# **Pearl Place Buildings 1 & 2**

**ADDENDUM IV**

**October 11, 2006**

## **Addendum #4**

Drawing file: 7. Electrical drw / 0517b E0.1.pdf

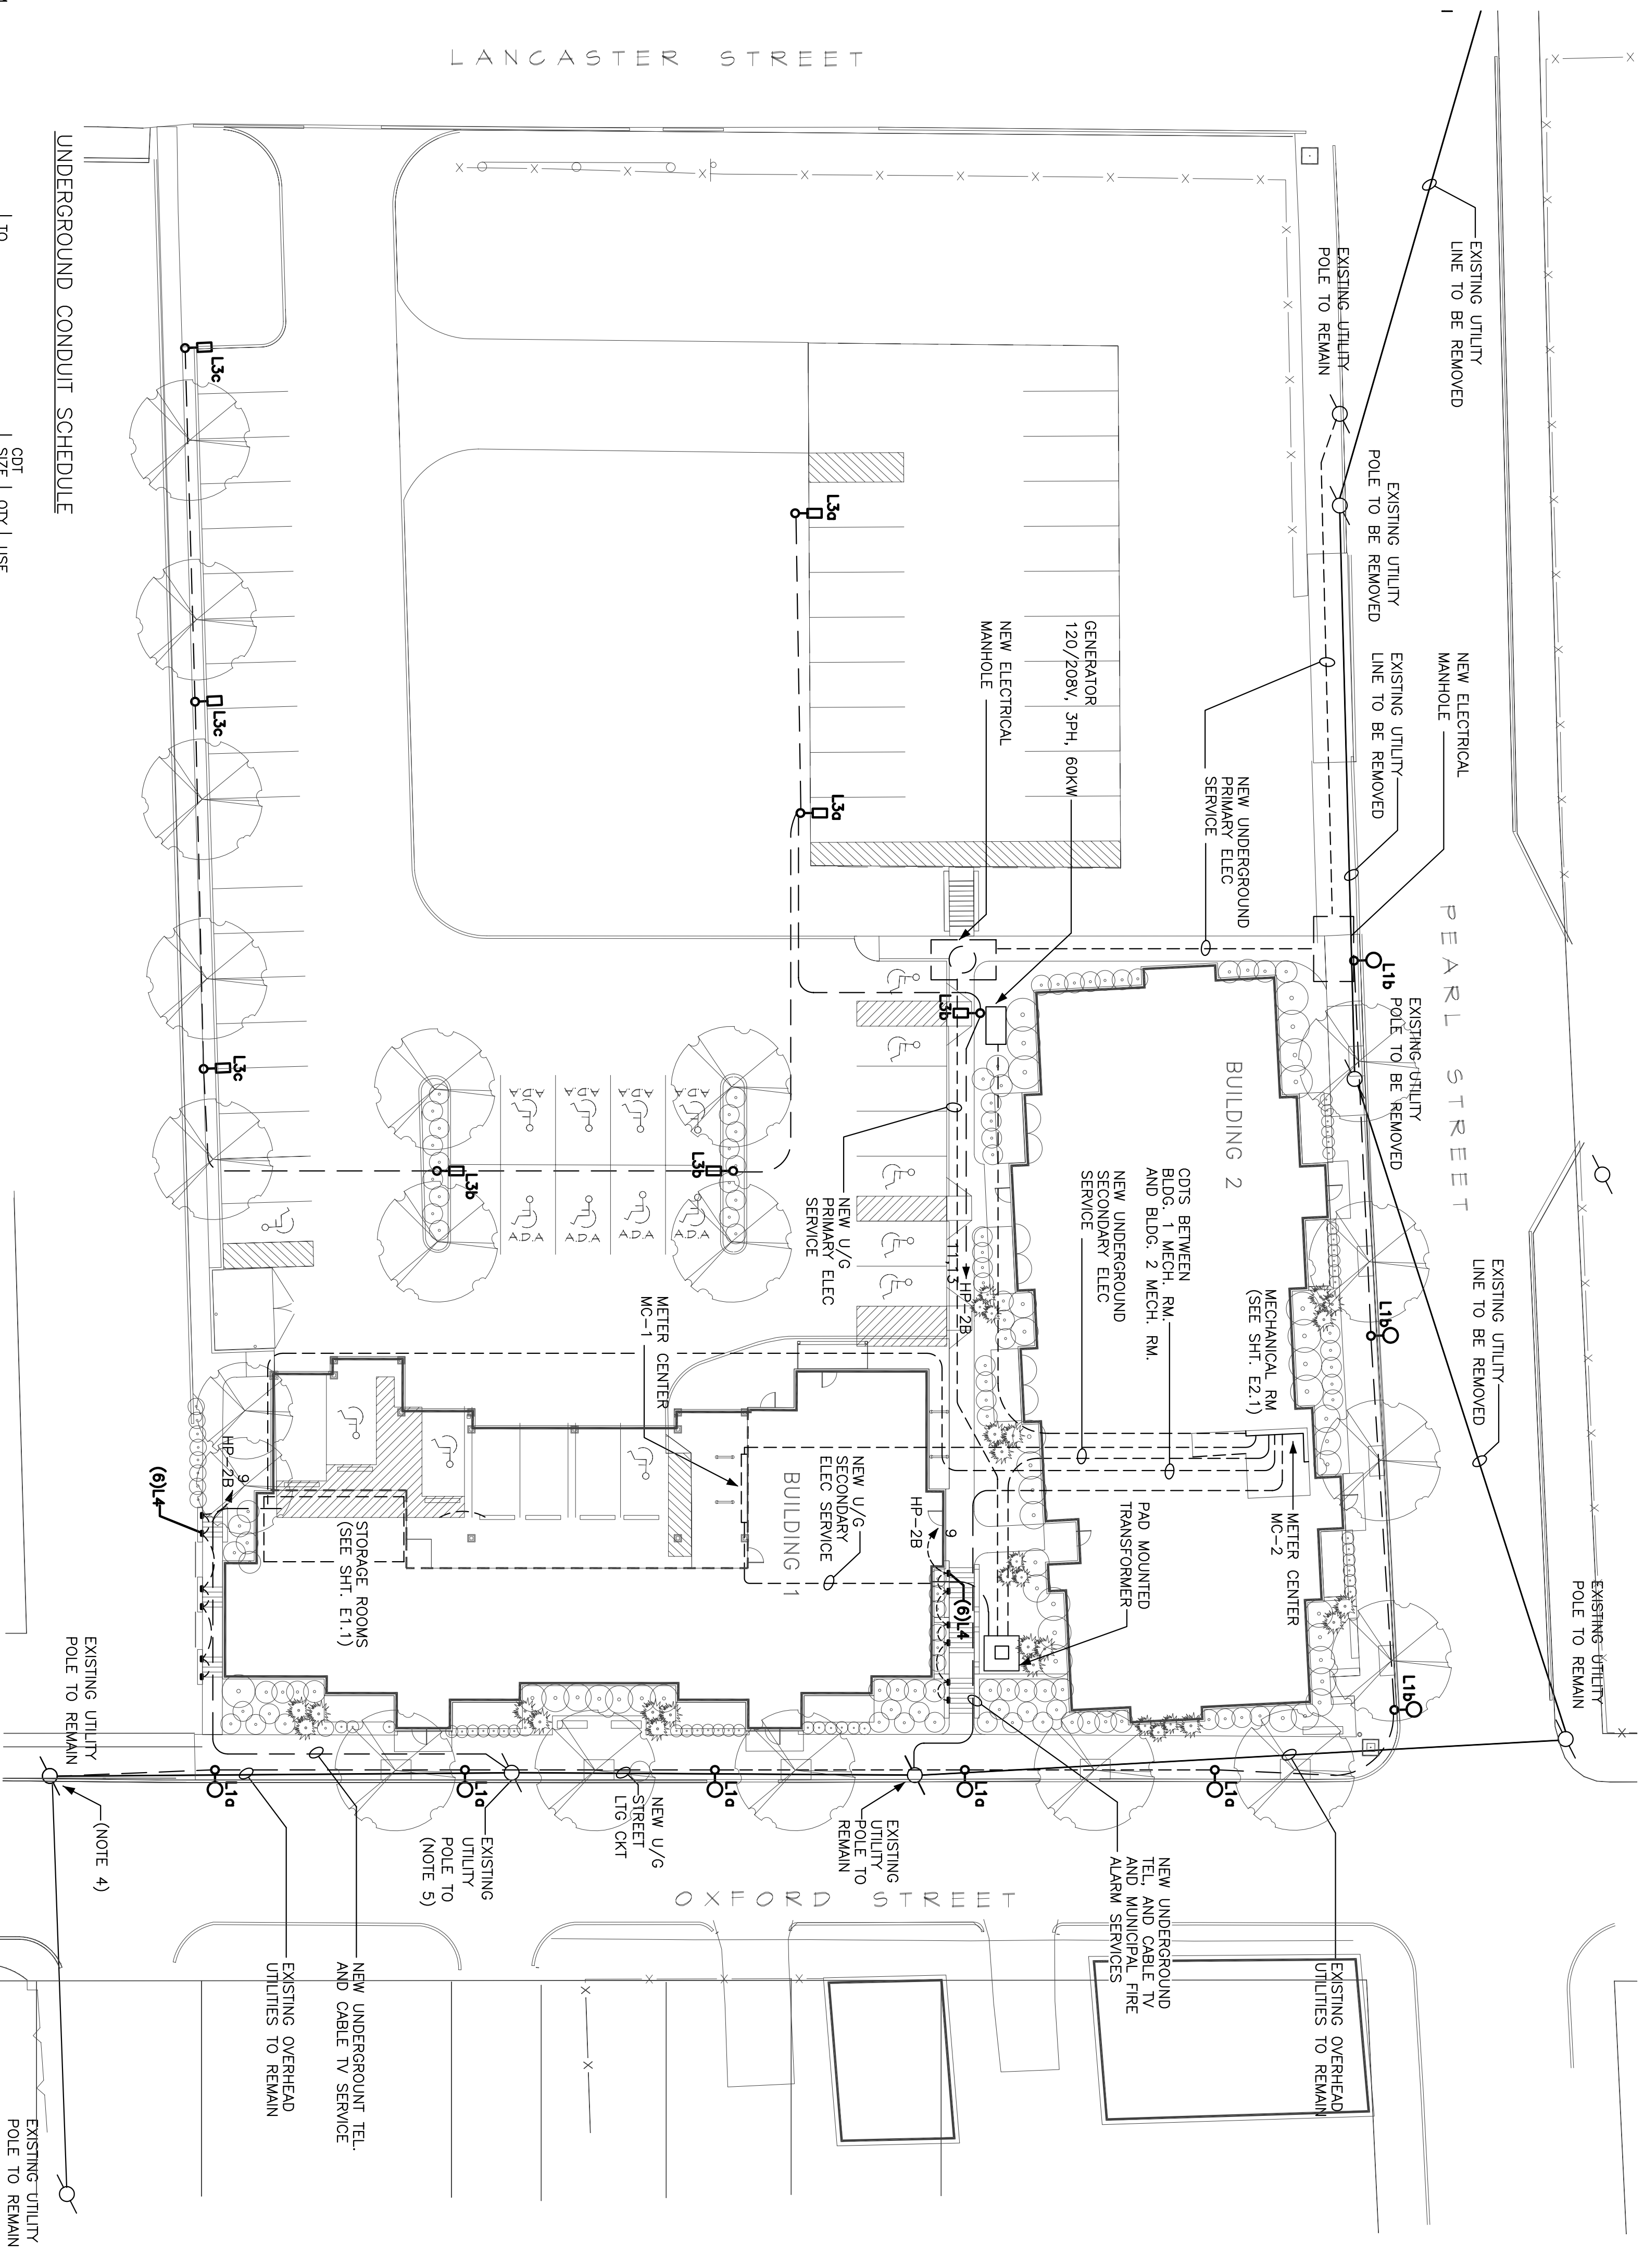
#### **E0.1 Site Electrical**

Change power on Oxford St. to underground as shown on the attached revised E0.1.
